**Re: Objection to MP08\_0244 MOD 1 Modification Request for Mixed Used Development at 23-37 Lindfield Avenue and 11 Havilah Lane, Lindfield**

As a resident of Lindfield, I/we wish to lodge an objection against the proposed Modification of the subject development based on the following grounds:

Drawing Title
SECTIONS

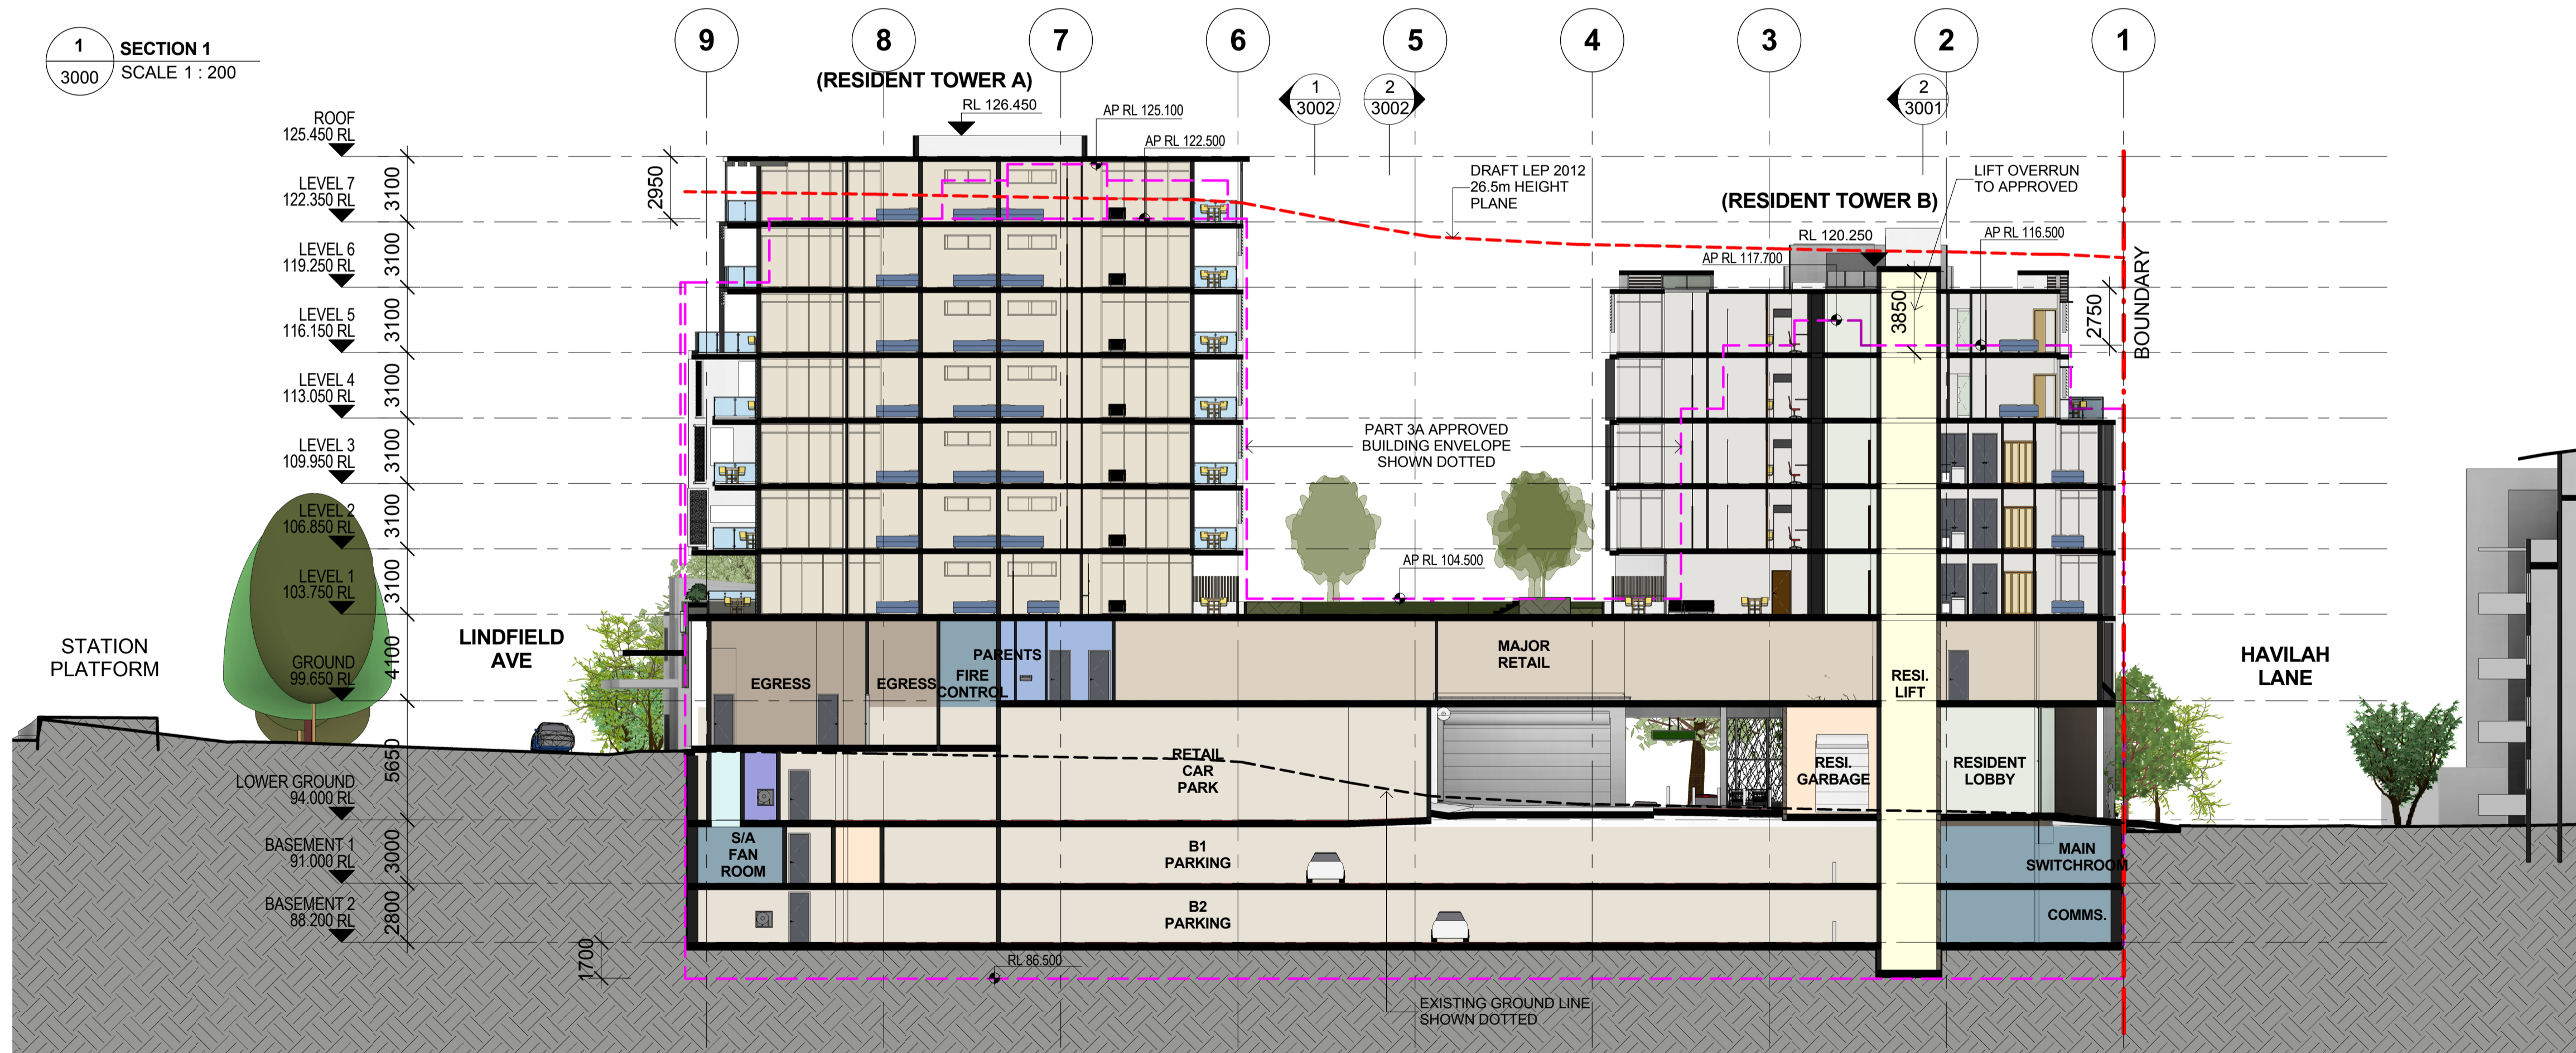
- The additional storeys create new adverse shadowing: a) for residents in the Havilah Lane apartments, particularly after 3pm b) for the popular outdoor café and central Lindfield hub area at 12 Tryon Road in afternoons, particularly in winter and c) for all commuters on the city bound Lindfield rail platform, instead of 50% of the year as approved, it will now be in shadow in the mornings 75% of the year

ELEVATIONS

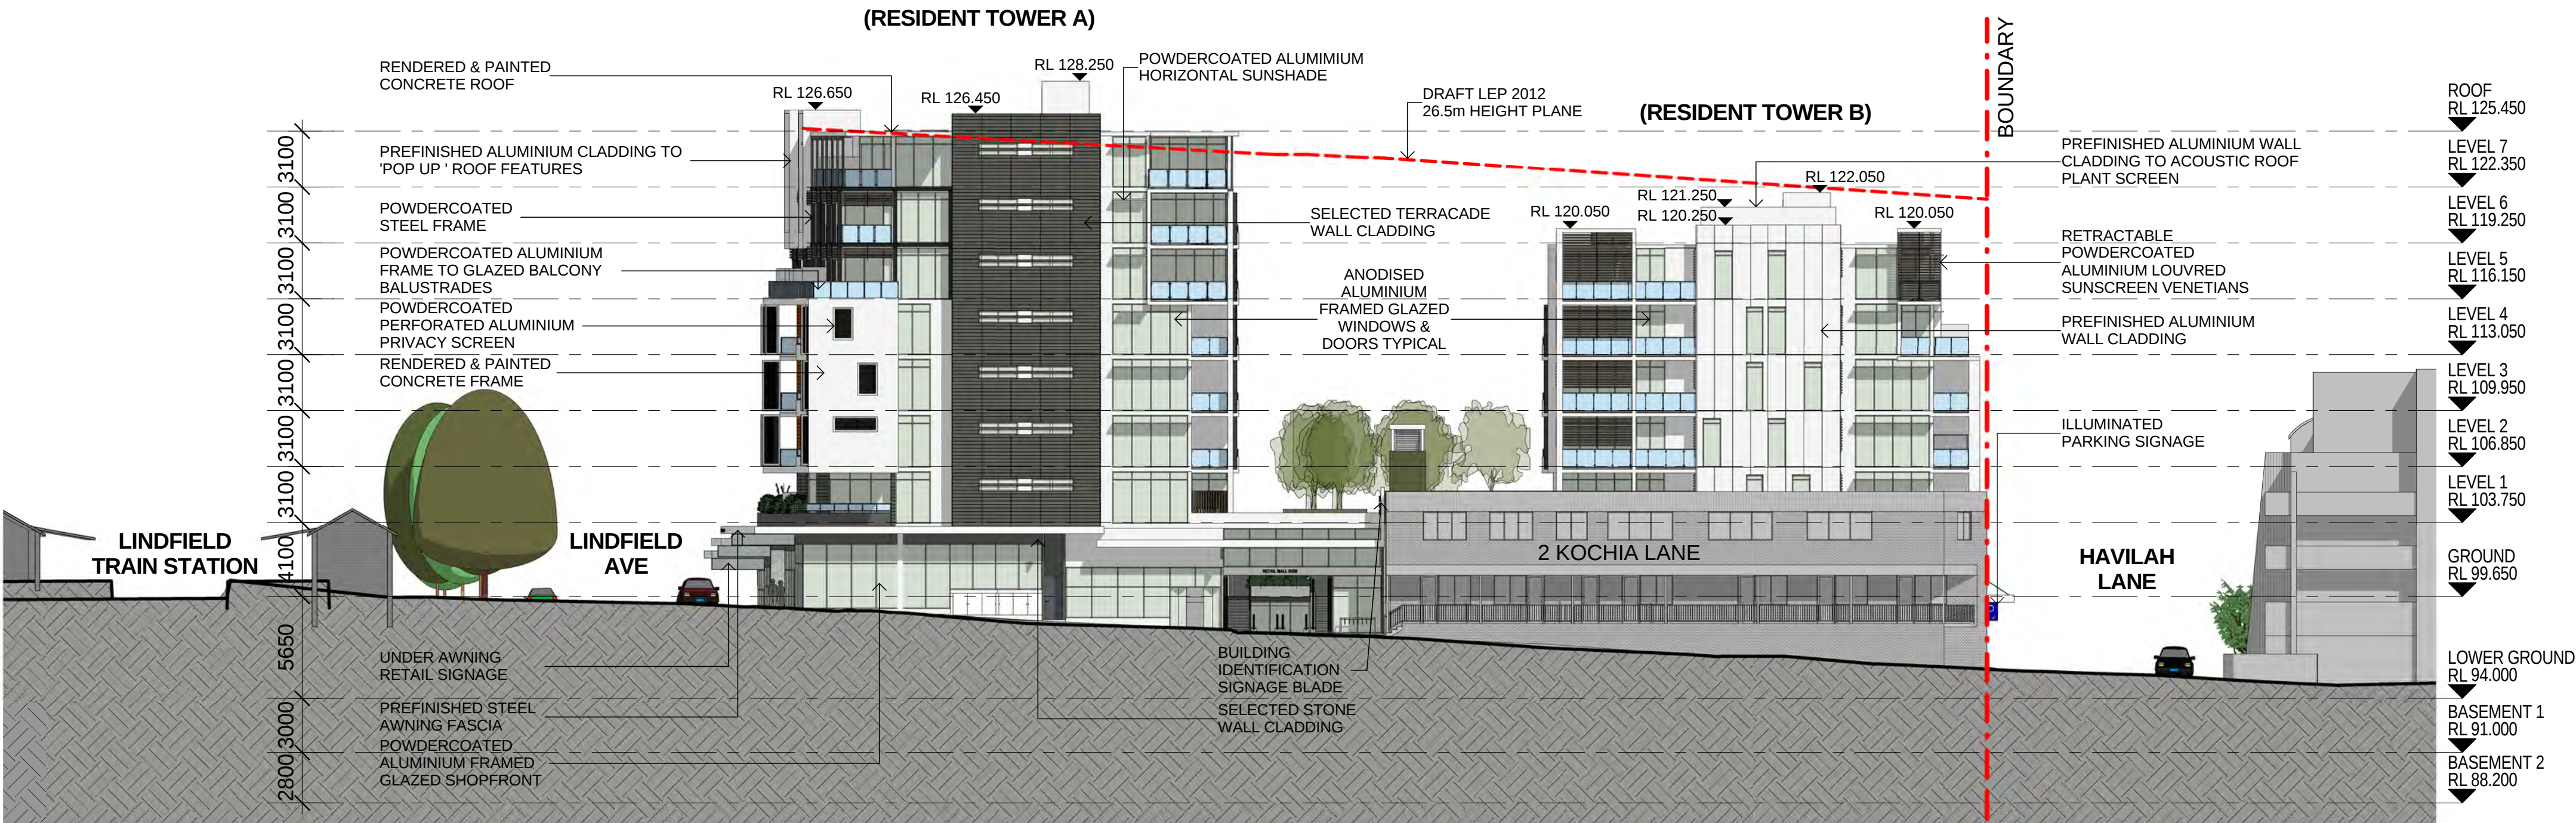
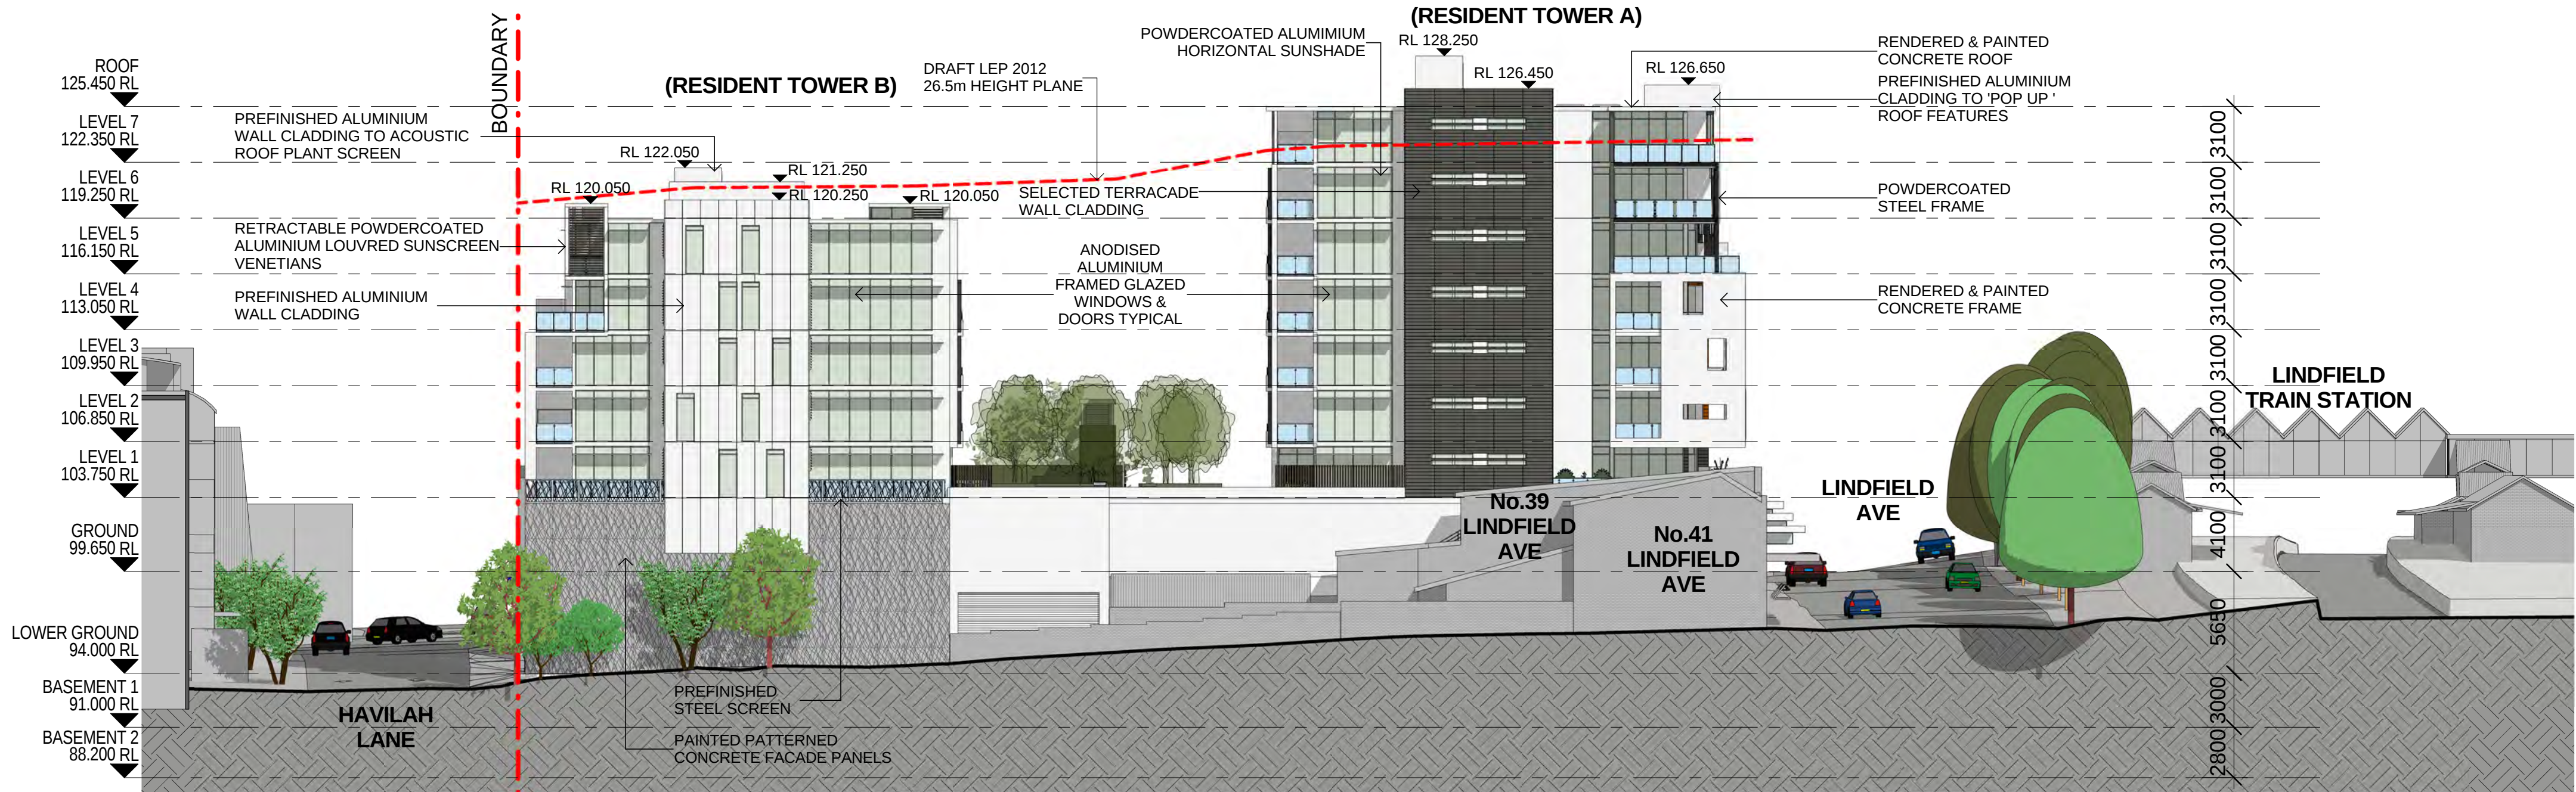
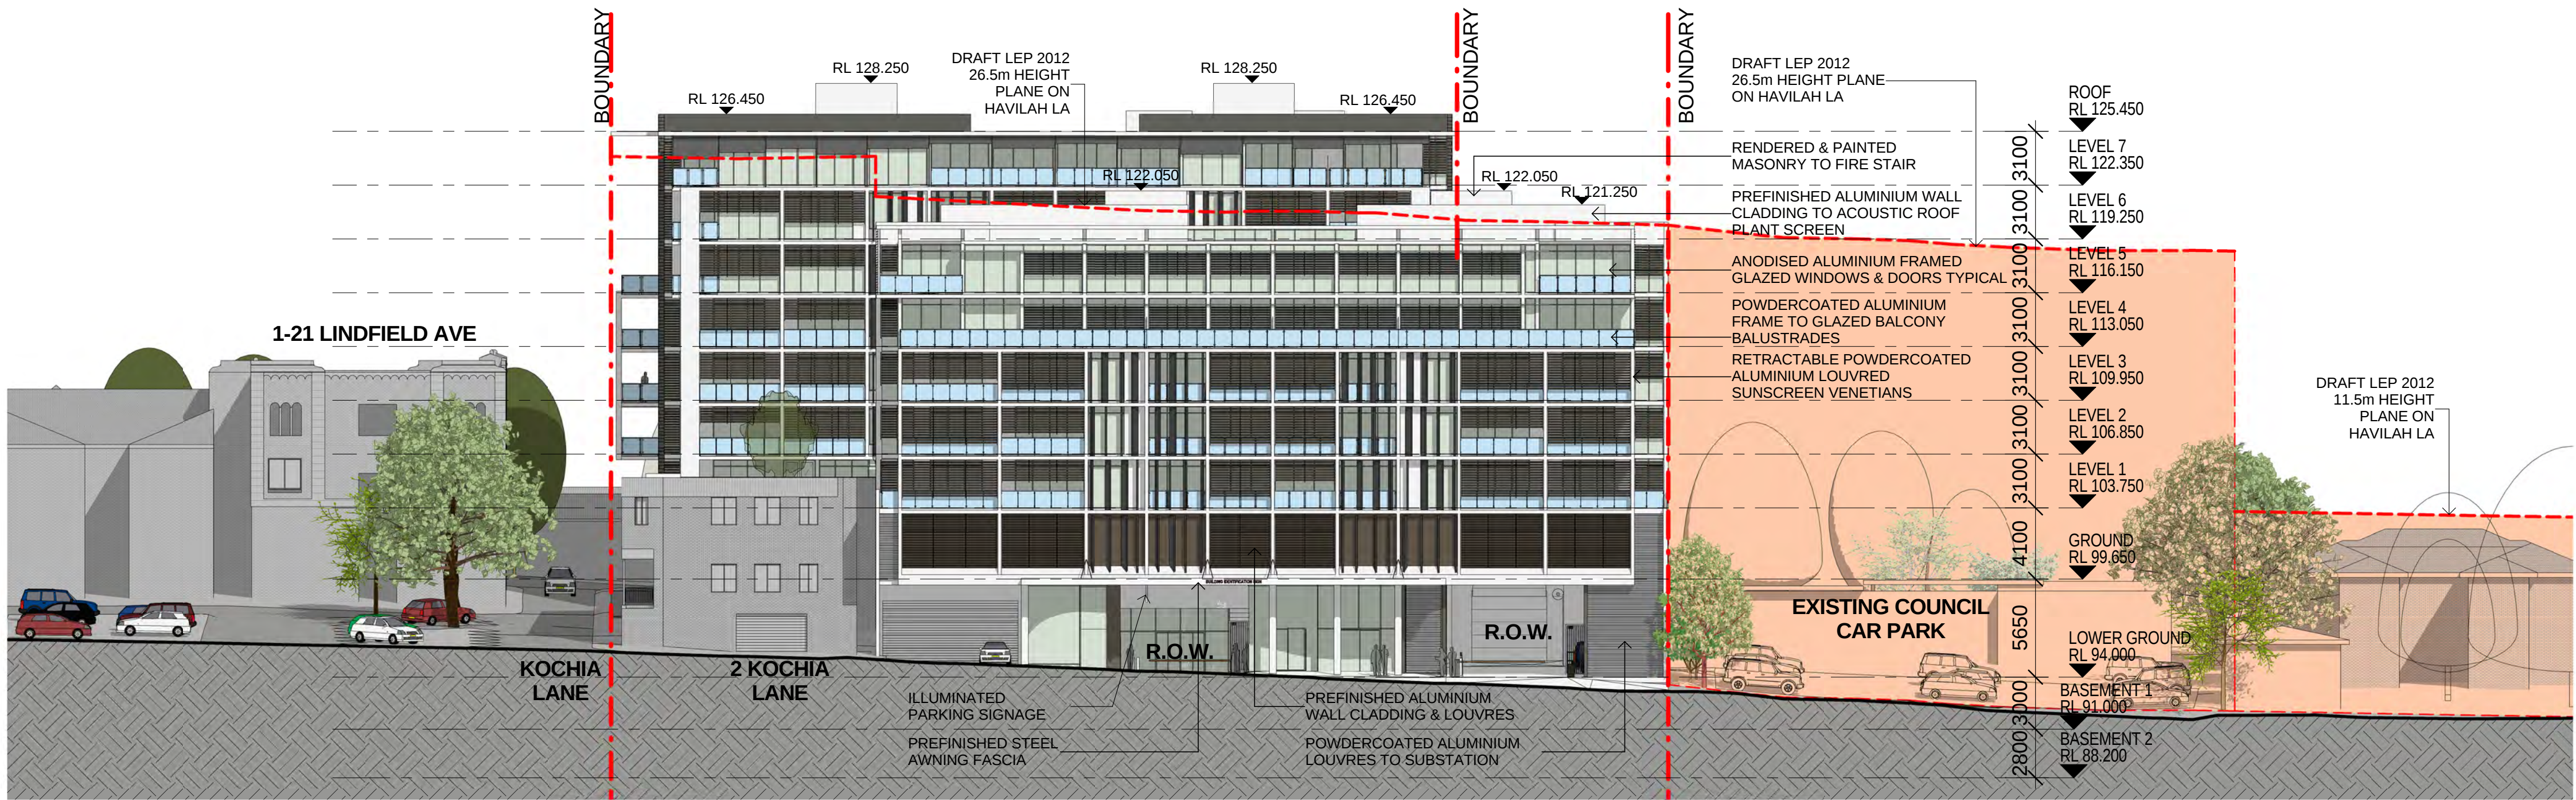
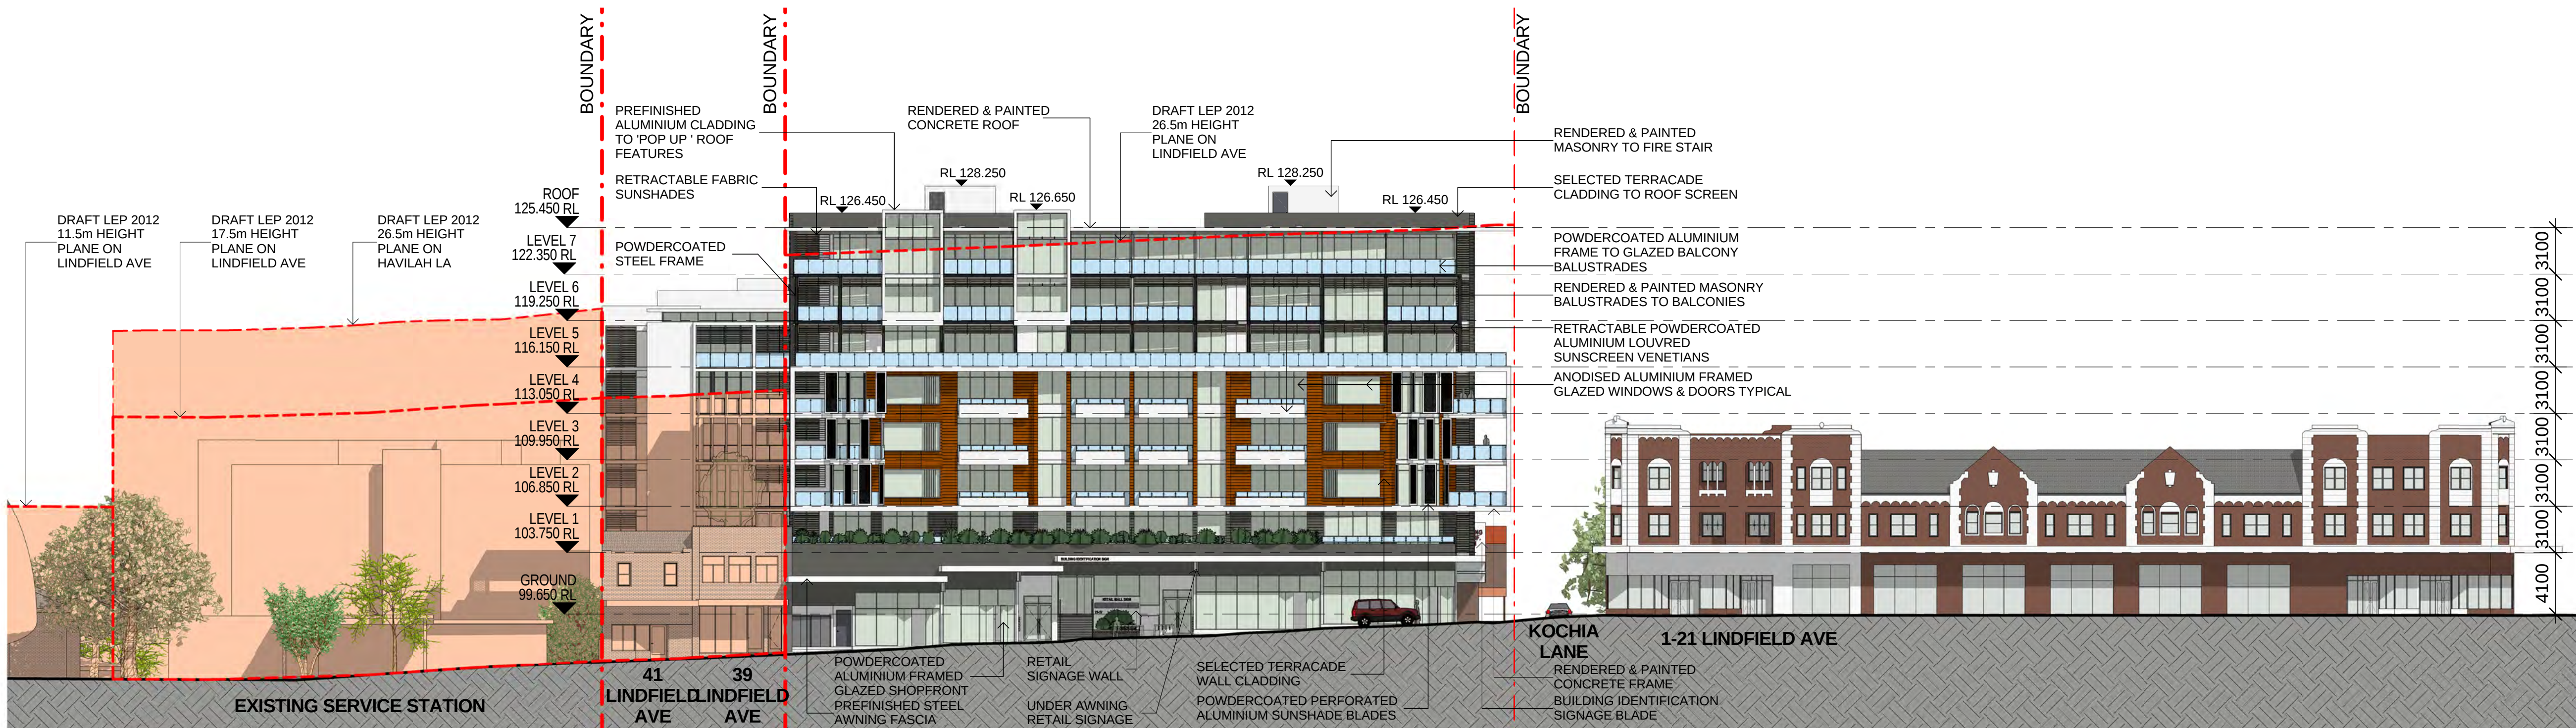
- The increase of an additional storey to both buildings: 8 storeys on Lindfield Avenue and 7 storeys on Havilah Lane creates excessive height and bulk and is out of character with the surrounding buildings, including the heritage listed adjacent building on Lindfield Avenue

- The additional storey (combined with less set back than the approved design) on Havilah Lane now creates privacy concerns for over 40 apartments in the adjacent 8 Havilah Lane, 8 Kochia Lane and 2-8 Milray Street residences
